City of Albuquerque Stormwater Construction Site Inspection Report

ESC File No.	M15E021C	Project Name:	Dutch Bros. NM0303
NPDES Id. No.	NMR1005GM	Location:	2131 Gibson Blvd SE
9/28/2023	Owner	Contractor	
Operator	Dutch Bros, LLC		
Contact name & title	Daniel Batty		
e-mail	daniel.batty@dutchbros.com		
Contact Phone #	541-955-4700		
COA Inspector	Chancellor English	Start/End Time:	1230pm
Construction Phase:	Excavation, utilities		
Type of Inspection:	Regular	Storm Event	Post Storm Event >0.25"
		311/Complaint	Follow Up
Weather at time of inspection?	Clear	Temperature:	~ 85
Estimated date of last storm 0.25" or greater			9/13/2023

Title:  
EROSION AND SEDIMENT CONTROL PLAN  
SWC GIBSON BLVD AND YALE BLVD  
ALBUQUERQUE, NM 87121

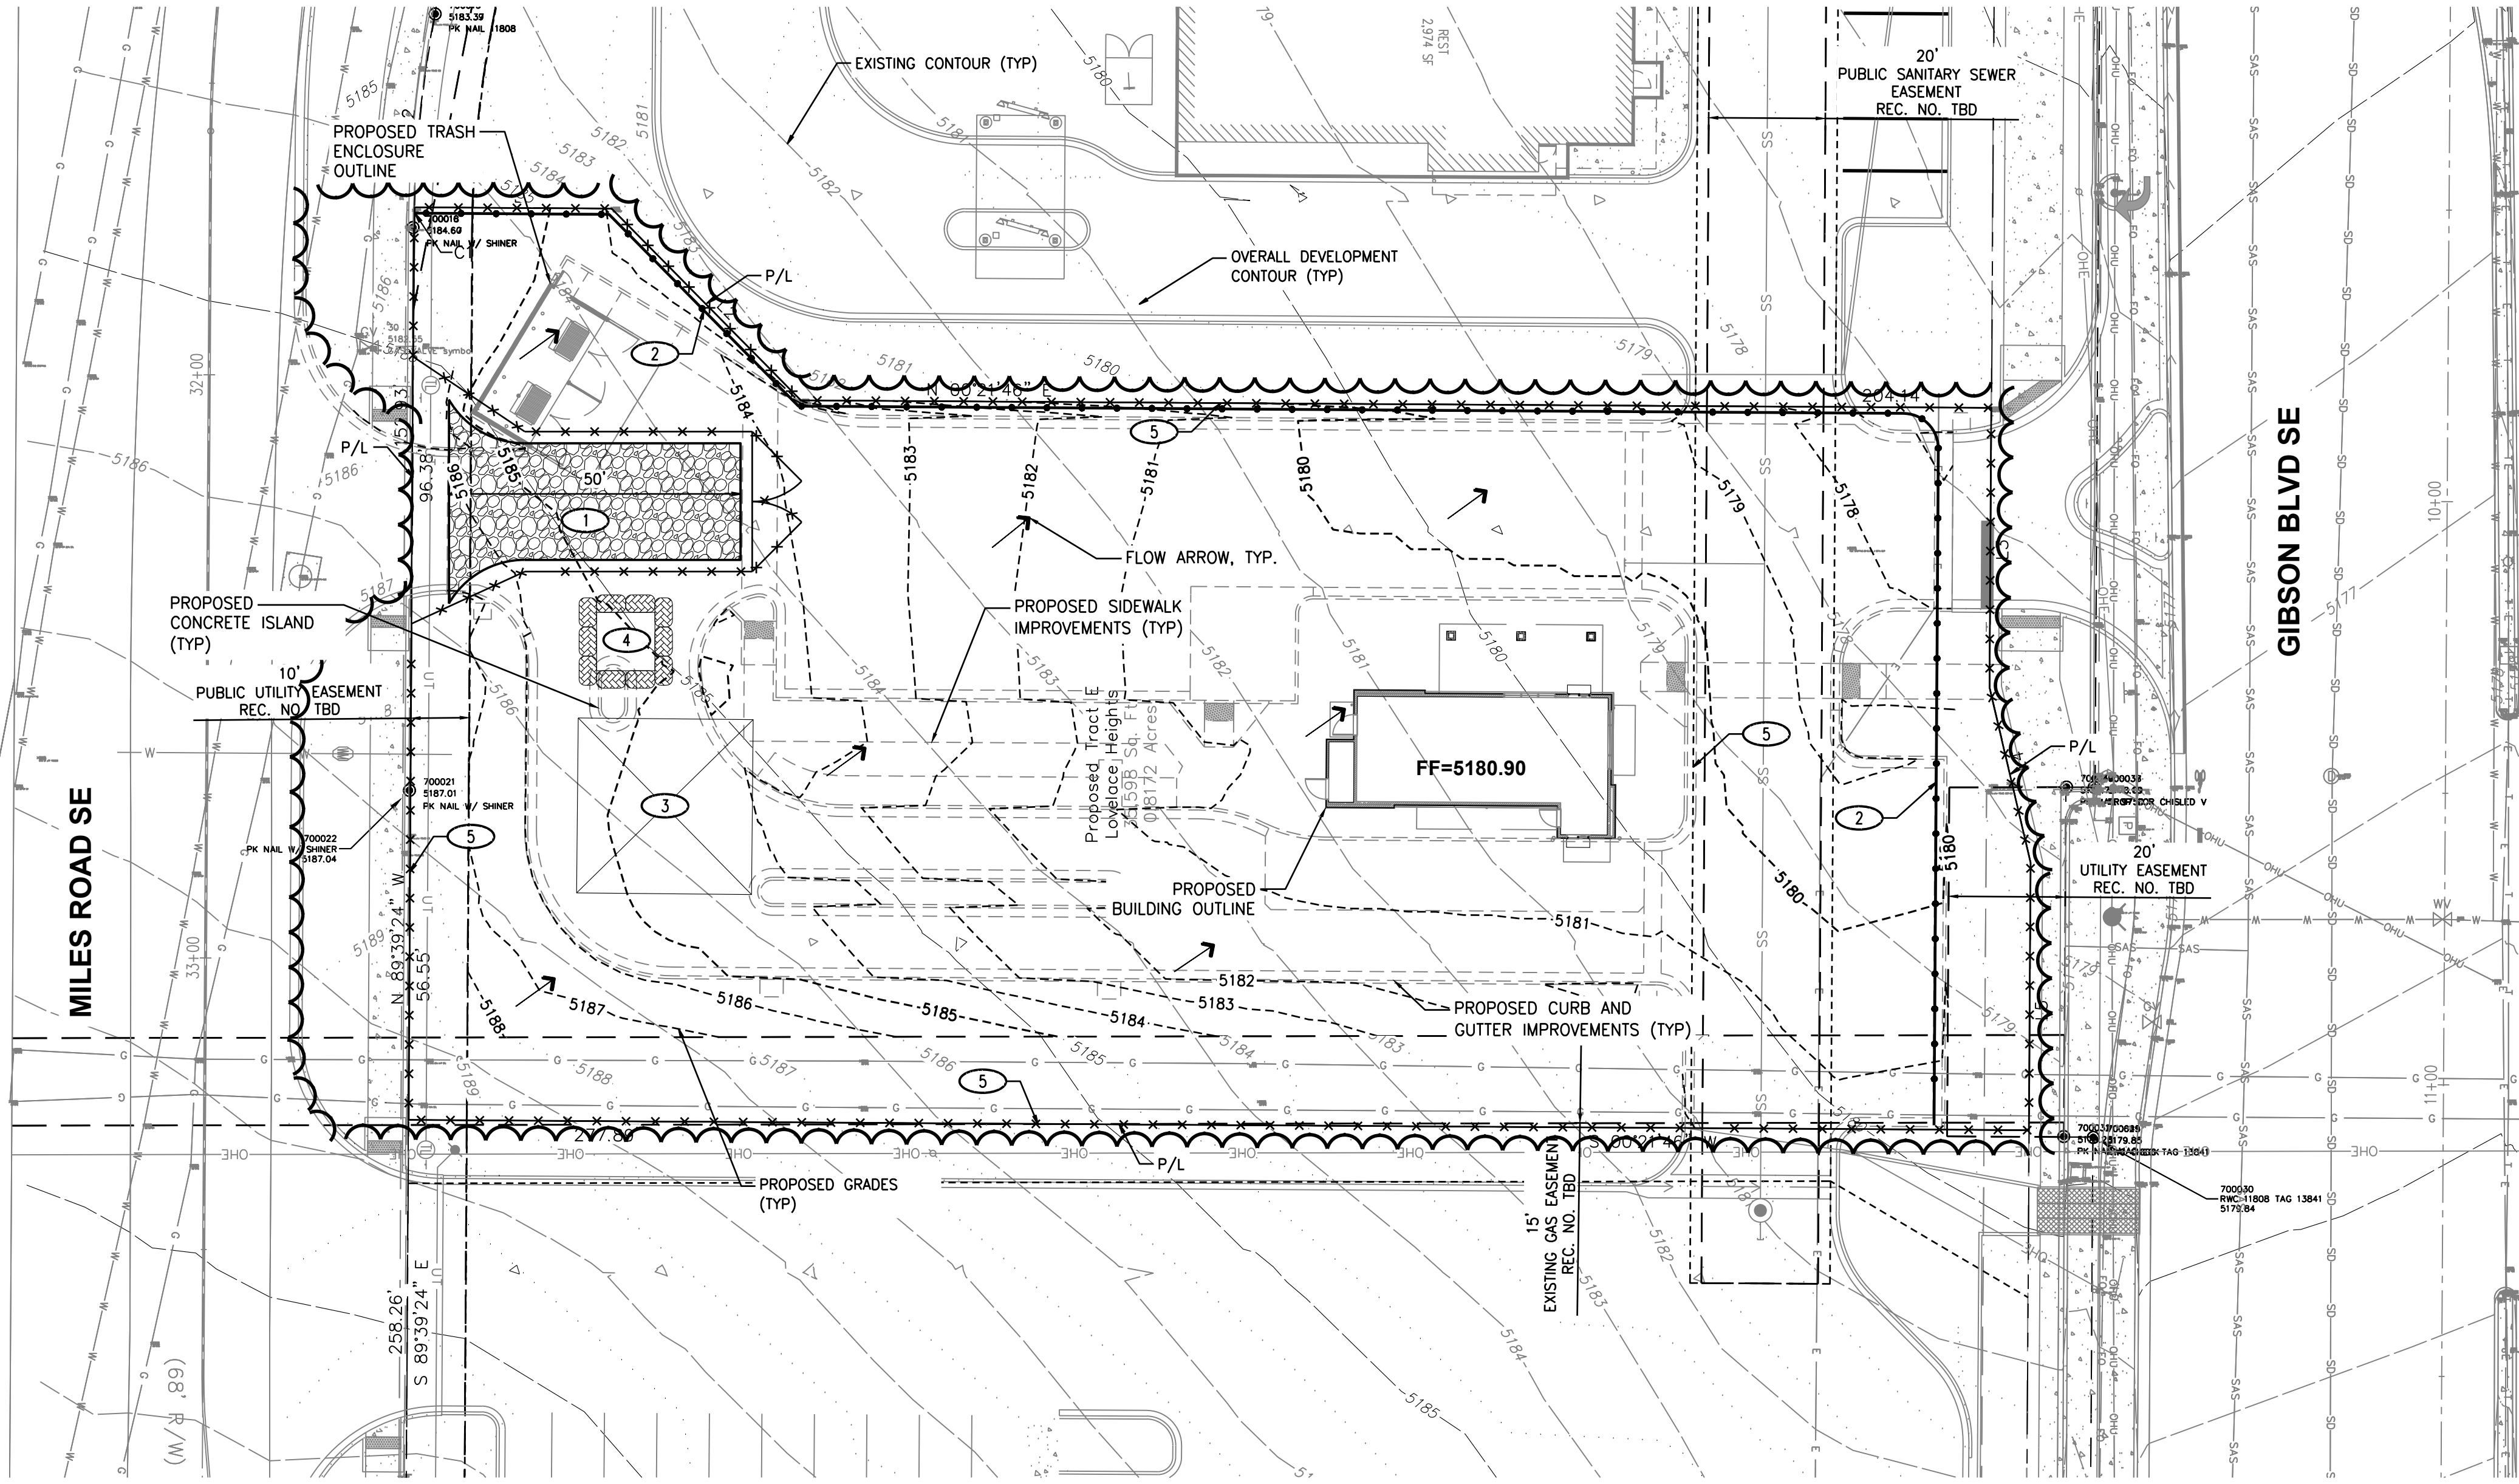
3	The perimeter silt fence needs maintenance and repair. There is land disturbance beyond the installed silt fence in violation of CGP Parts 2.1.3 and 2.2.3 and the silt fence has been inundated to the point of sediment discharge in violation of CGP Part 2.1.4. Required mitigation: You must install sediment controls along any perimeter areas of the site that are downslope from any exposed soil or other disturbed areas per CGP Part 2.2.3. You must complete the installation of stormwater controls by the time each phase of construction activities has begun, per CGP Part 2.1.3. You must also ensure all stormwater controls are maintained and remain in effective operating condition during permit coverage and are protected from activities that would reduce their effectiveness per CGP Part 2.1.4.		
4	Sediment discharge was observed leading from the site into the ROW and leading onto Gibson Blvd. These discharges stem from poorly installed or maintained perimeter stormwater controls, in violation of CGP Parts 1.2.1, 2.1.2, and 2.1.4. Required mitigation: CGP Part 1.2.1 authorizes stormwater discharges from construction activity provided that appropriate stormwater controls are designed, installed, and maintained. Both noted sediment discharges occurred due to lack of maintenance and poor design and/or installation. CGP Part 2.1.2 requires the desing and installation of all stormwater controls in accordance with good engineering practices and CGP Part 2.1.4 requires that all stormwater controls are maintained and remain in effective operating procedures.

5	There was concrete washout in an un-lined pit (on bare ground) in violation of CGP Part 2.3.4. Required mitigation: Direct wash water into a leak-proof container or leak-proof and lined pit designed so no overflows can occur due to inadequate sizing or precipitation and do not allow liquid wastess to be disposed of through infiltration or to otherwise be disposed of on the ground per CGP Part 2.3.4.
